Pre-Application Consultation Report:
Land Rear of 40 Victoria Road
Fleur De Lis

Applicant: Mr. & Mrs. Carrafa

Location: Land Rear of 40 Victoria Road Fleur De Lis

Proposal: Full planning application for demolition of 40 Victoria Road, erection of 5 detached dwellings and formation of a new access.

Figure 4: Proposed access arrangements

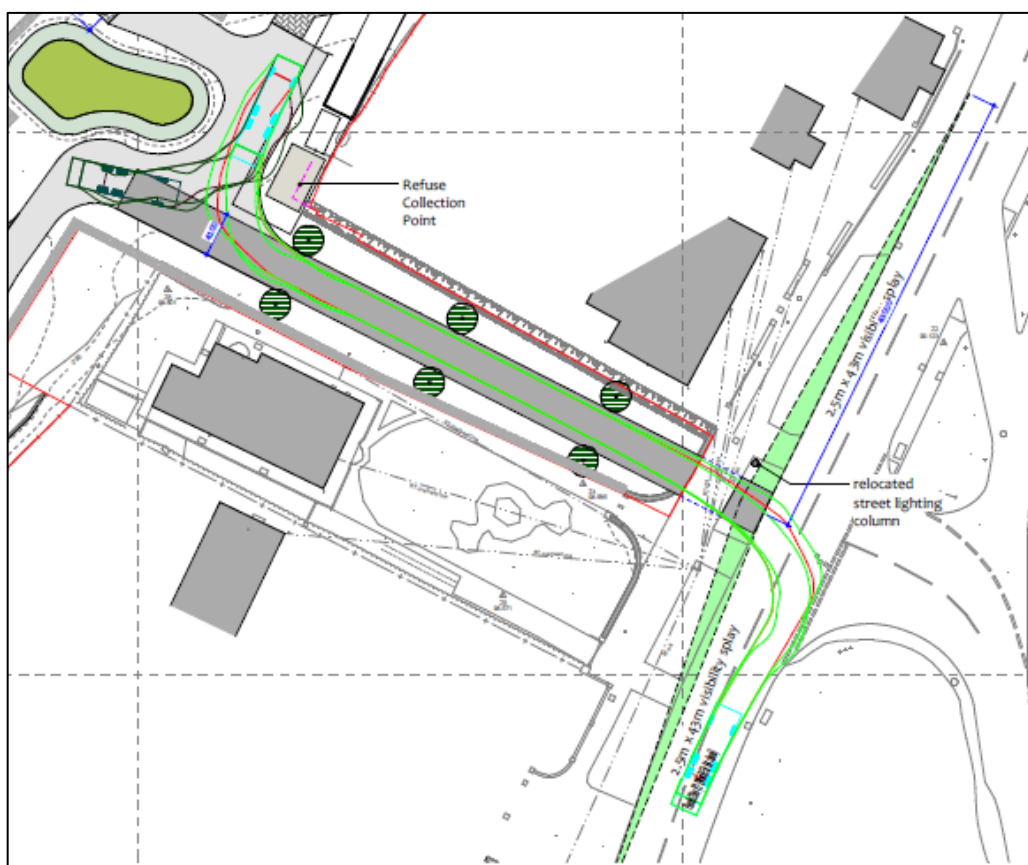
- 4.6. Comments are made that the plans need to show 3 parking spaces for each plot (of an appropriate size) and a vehicle swept path to demonstrate that the largest vehicles can safely turn. The comments also state that the existing street lighting column should be relocated and the existing access point, formerly used by number 40, should be stopped up prior to the new access being brought into use.

- 5.4. This plan will be included in the planning application and a copy has been separately sent to the Highway Authority for completeness.
- 5.5. The requirement to relocate the lighting column and stop up the existing access can be dealt with as part of the license requirements with the Highway Authority and, if considered necessary by the LPA, can be dealt with by a Grampian style condition requiring both to have been carried out prior to occupation.
